Application No: A/18/26/HH
Site Address: Lucks Mill House Old Mill Lane Angmering BN16 4AQ
Description of works: Extension to attached garage.

OWPC82526

Trees:
T1 - Palm - to be retained.
T2 - Ash - to be removed.
T3 - Apple - to be removed.
T4 - Apple - to be removed.
T5 - Birch - to be retained.

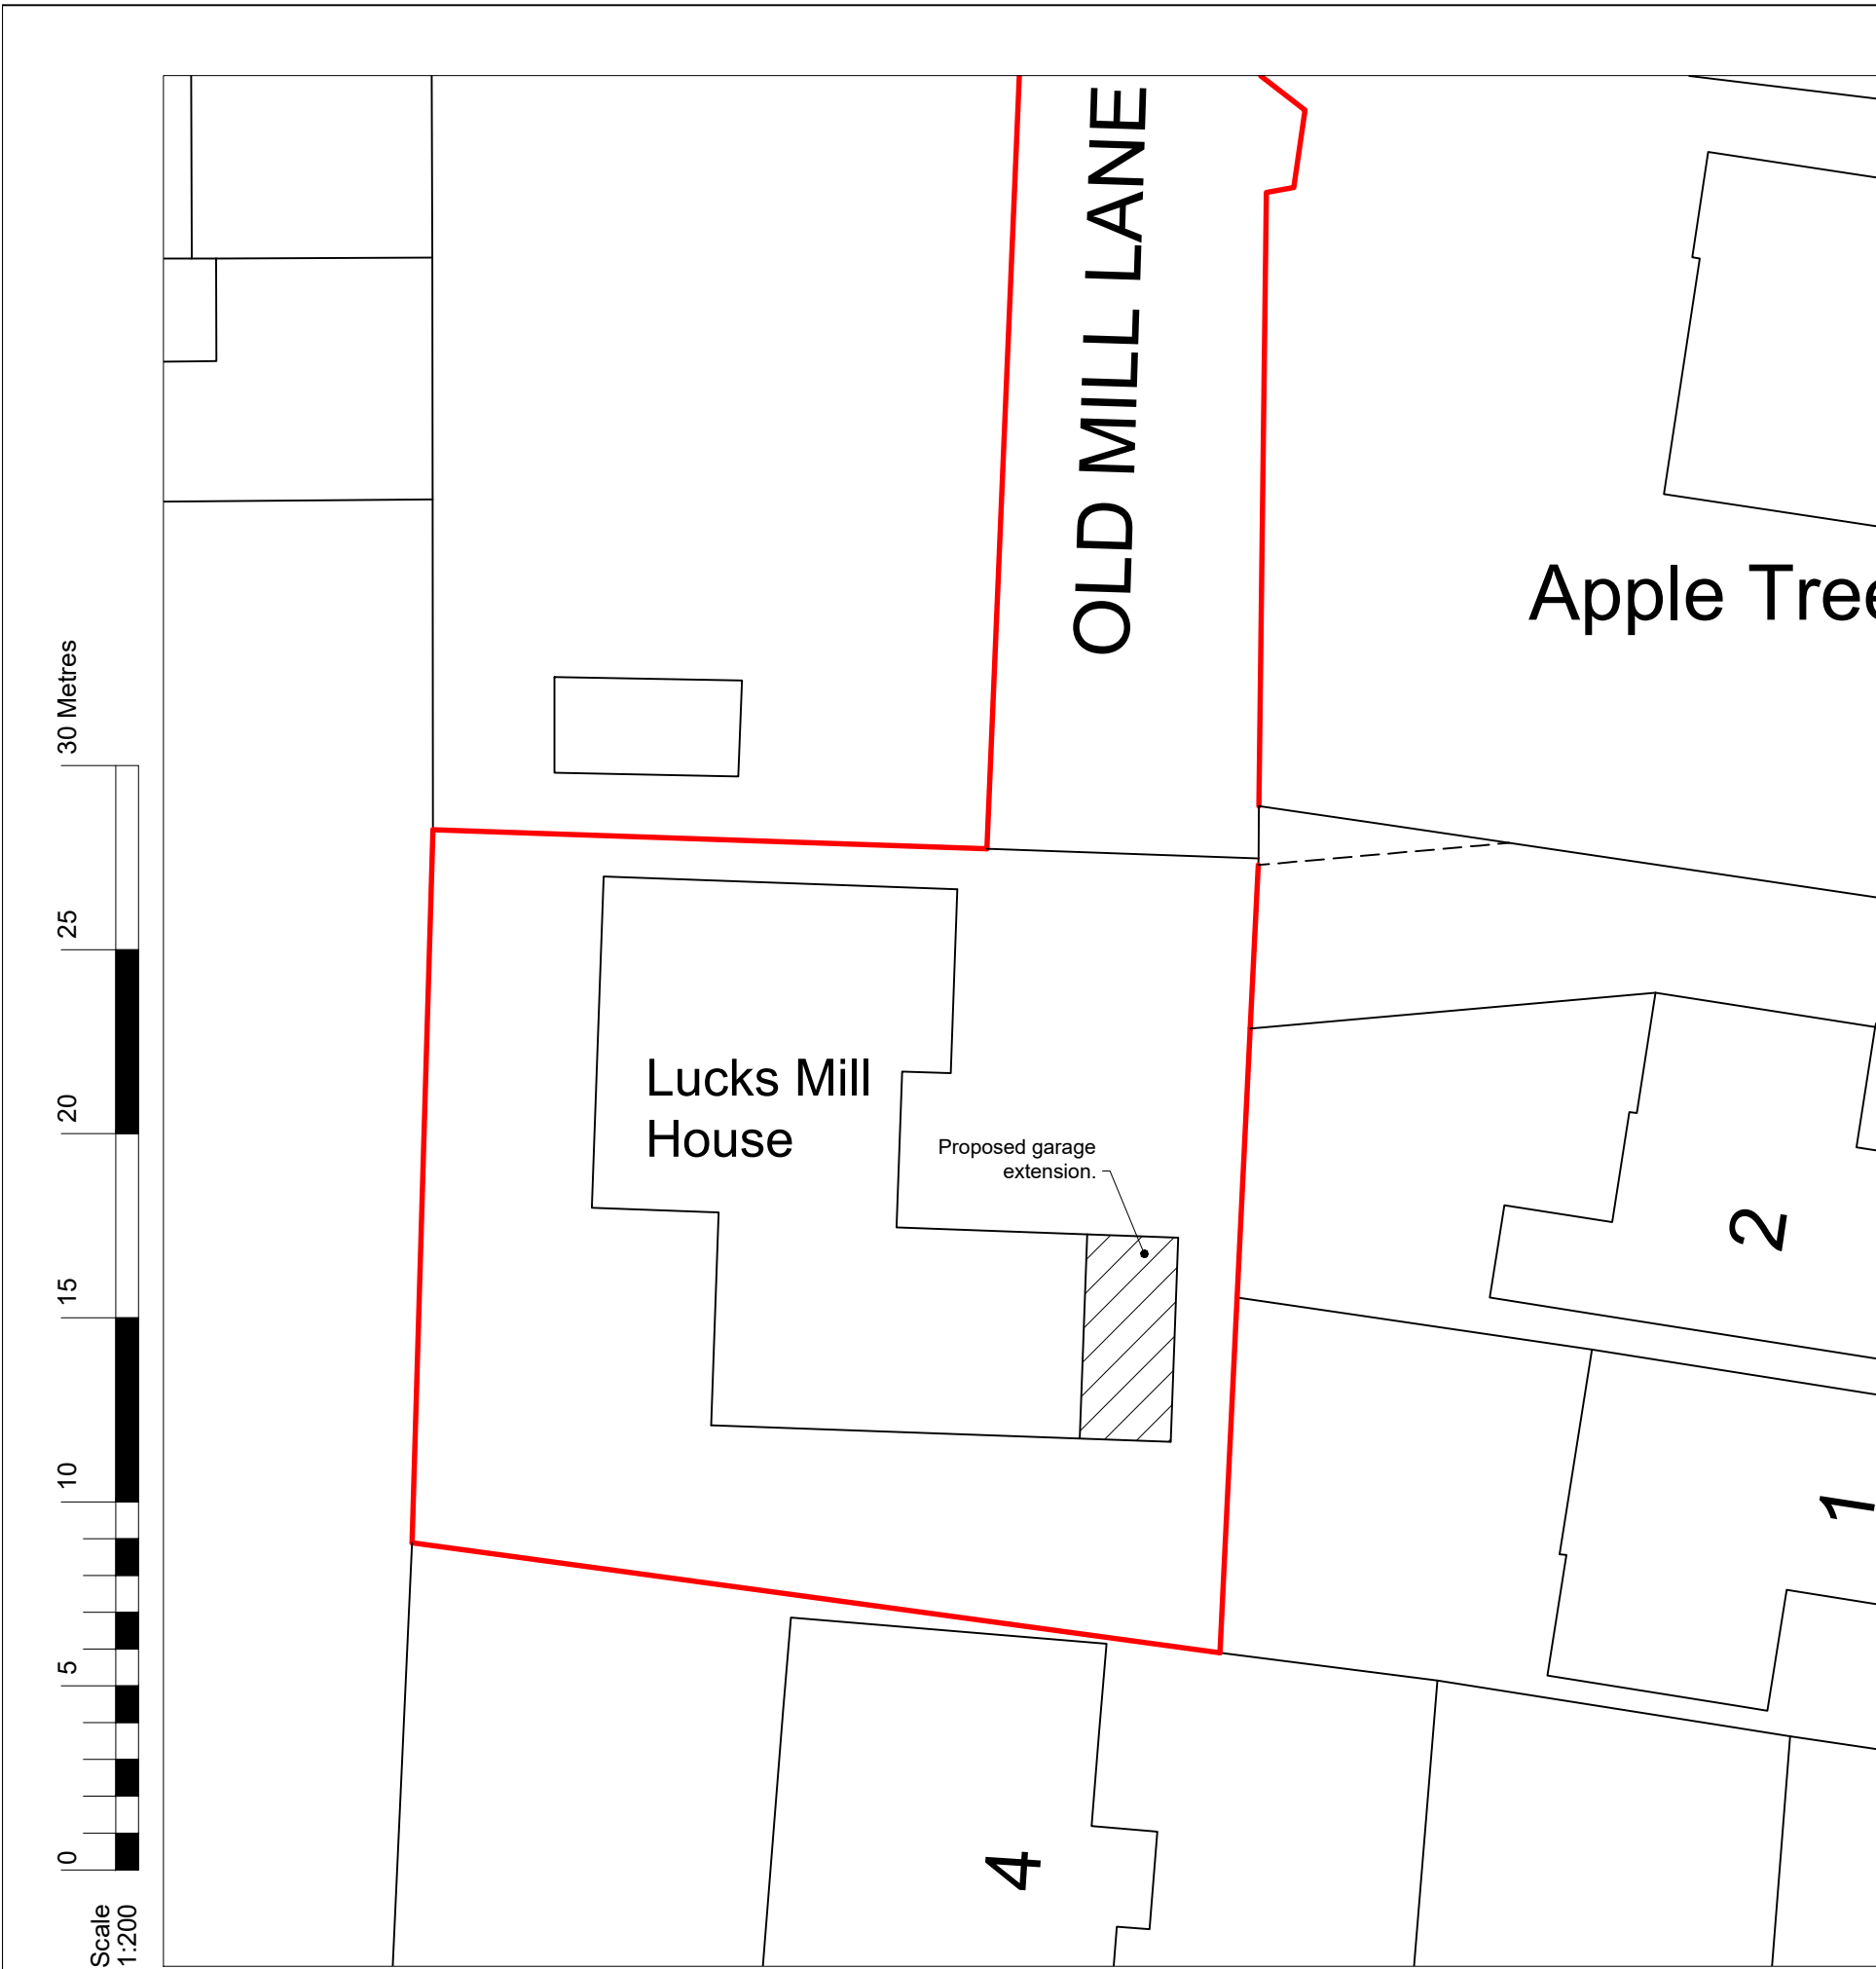
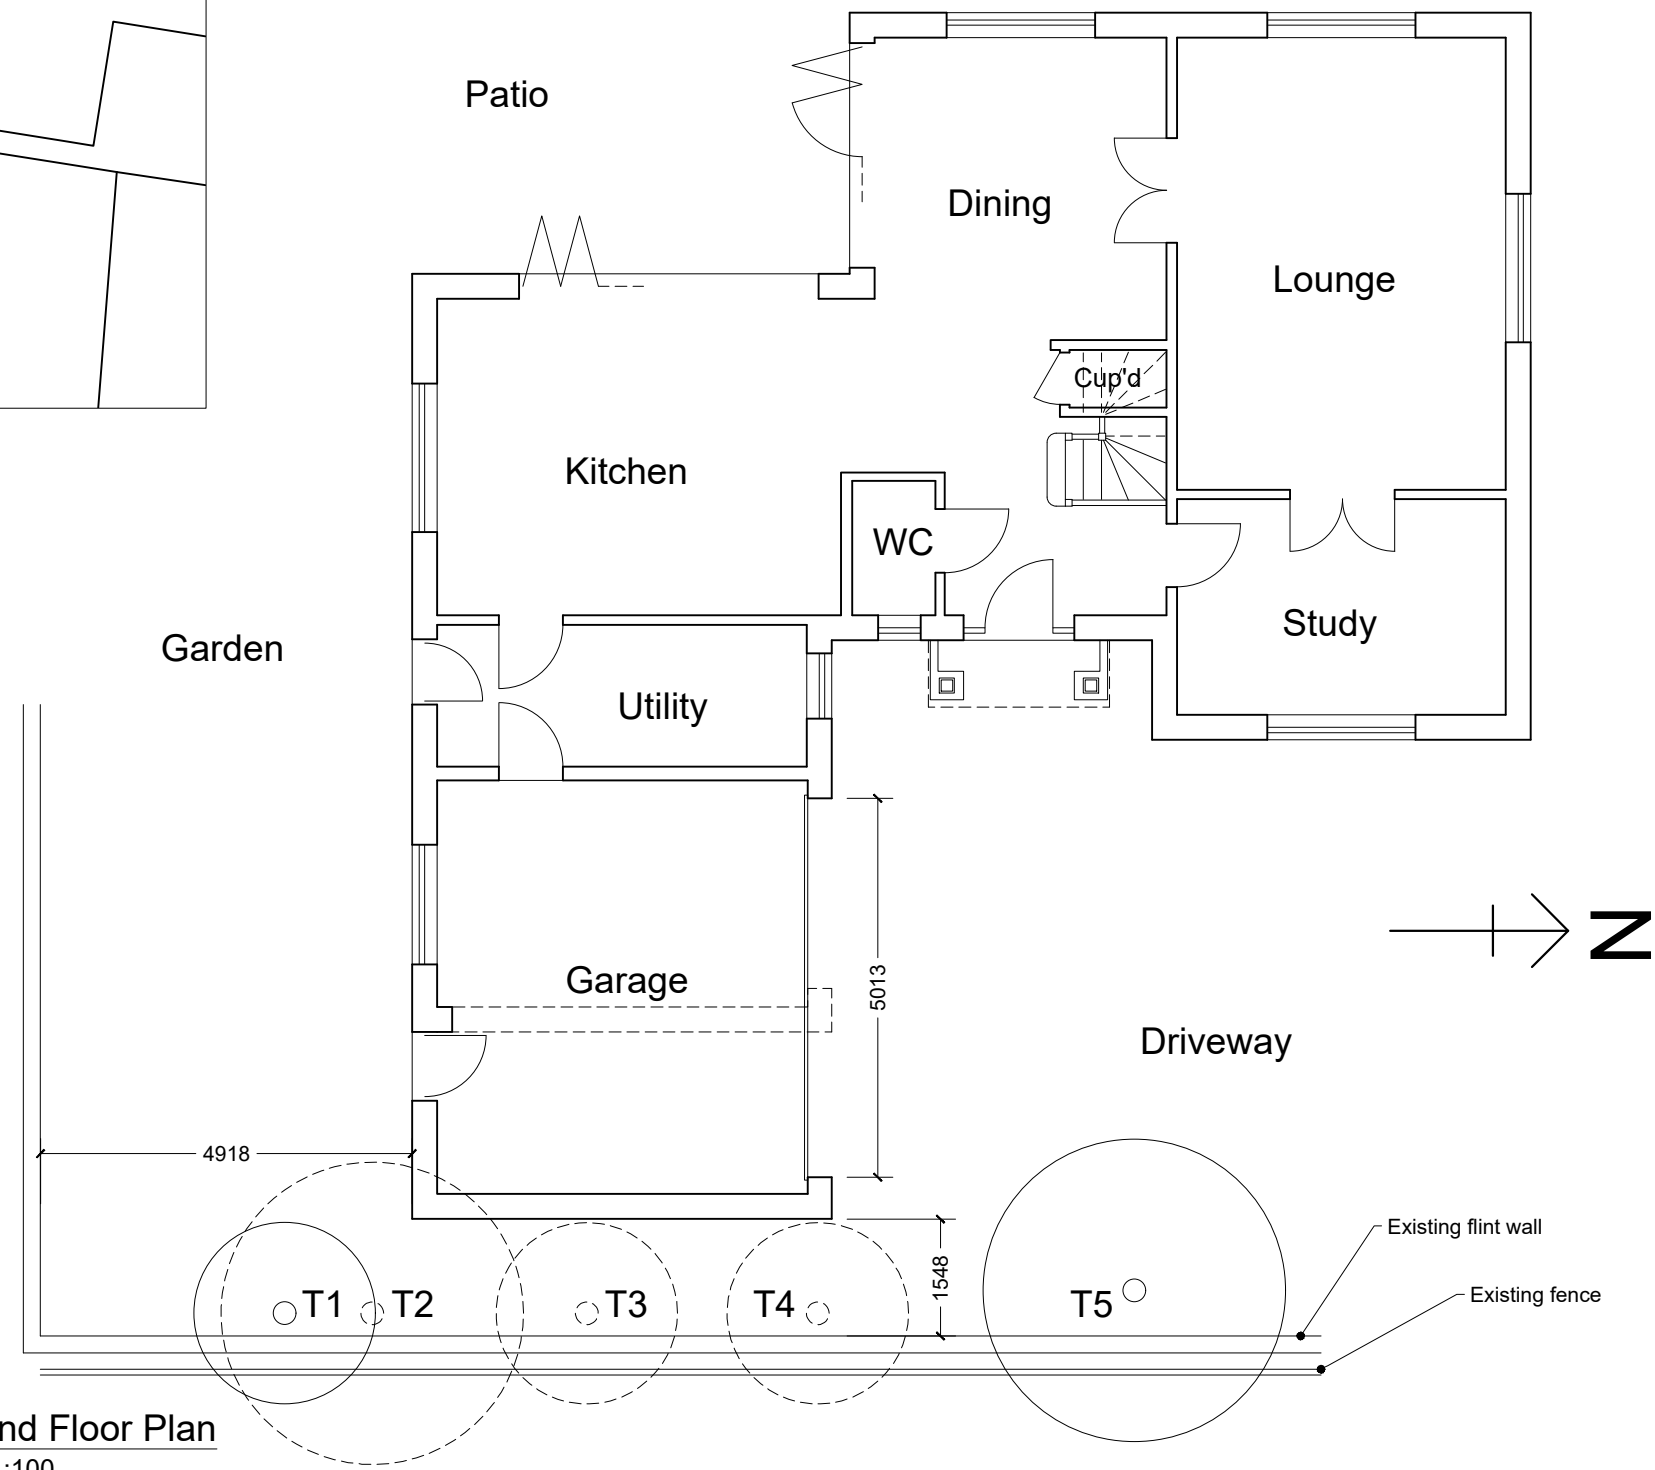
APC has no objection to this extension provided it is for the use as described, namely a garage. APC also asks that in accordance with its Tree Policy the trees to be removed are replaced as semi-mature trees and not whips, either on the property or in accordance with other location advice from APC.
